Online Comment

Application H17-1152-19
Location La Castagna Cheal Road Surfleet PE11 4BA
Proposal Change of use from agricultural barns to dwelling - resubmission of H17-1140-18

Name Sue Armour
Address Environmental Protection Officer SHDC PE11 2XE

Date Submitted 06-02-20
For/Against Comments

SOIL SAMPLE		
Sample ID	Depth (m,bgl)	Sample position
ES1	Composite	Arisings
ES2	Composite	Arisings
ES3	Composite	Arisings
ES6	1.90m	Base
ES8	1.00m	Side
ES9	0.70m	Side
ES11	0.80m	Side

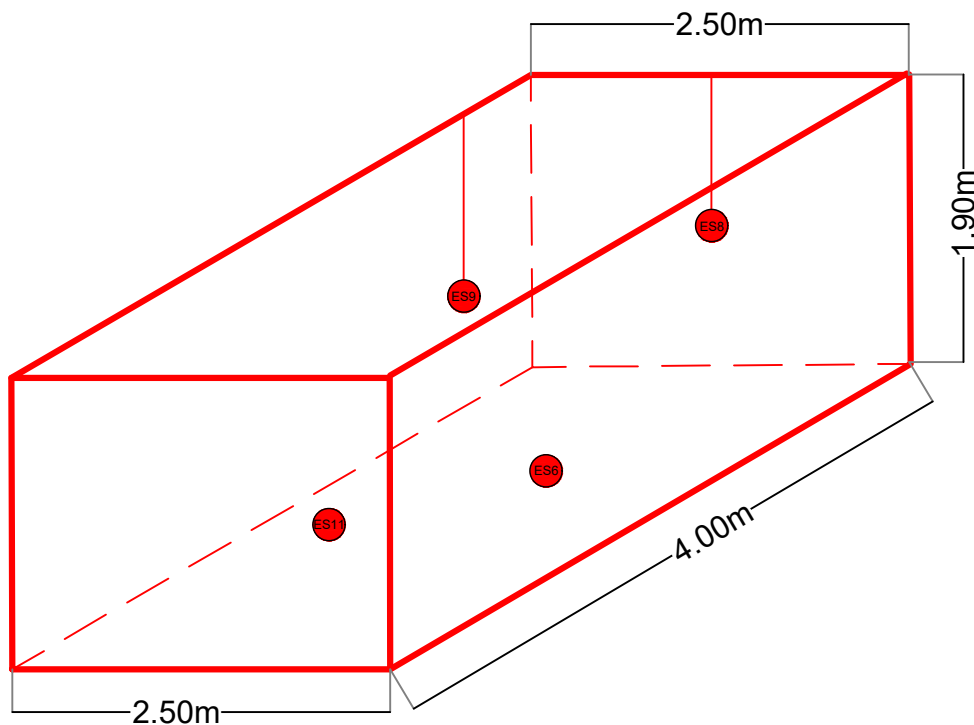
Limited information, in the form of photographs, an email dated 12/8/2019, test data and a sampling plan, has been submitted with respect to the below ground fuel tank.

The levels of PAH's in the arising's were higher than would be expected, and yet the samples from the sides/ base were not sampled for this. No information was given regarding the disposal of the arising's or the backfill material.

I therefore recommend that parts ii-iv of the standard land contamination condition be applied to this application.
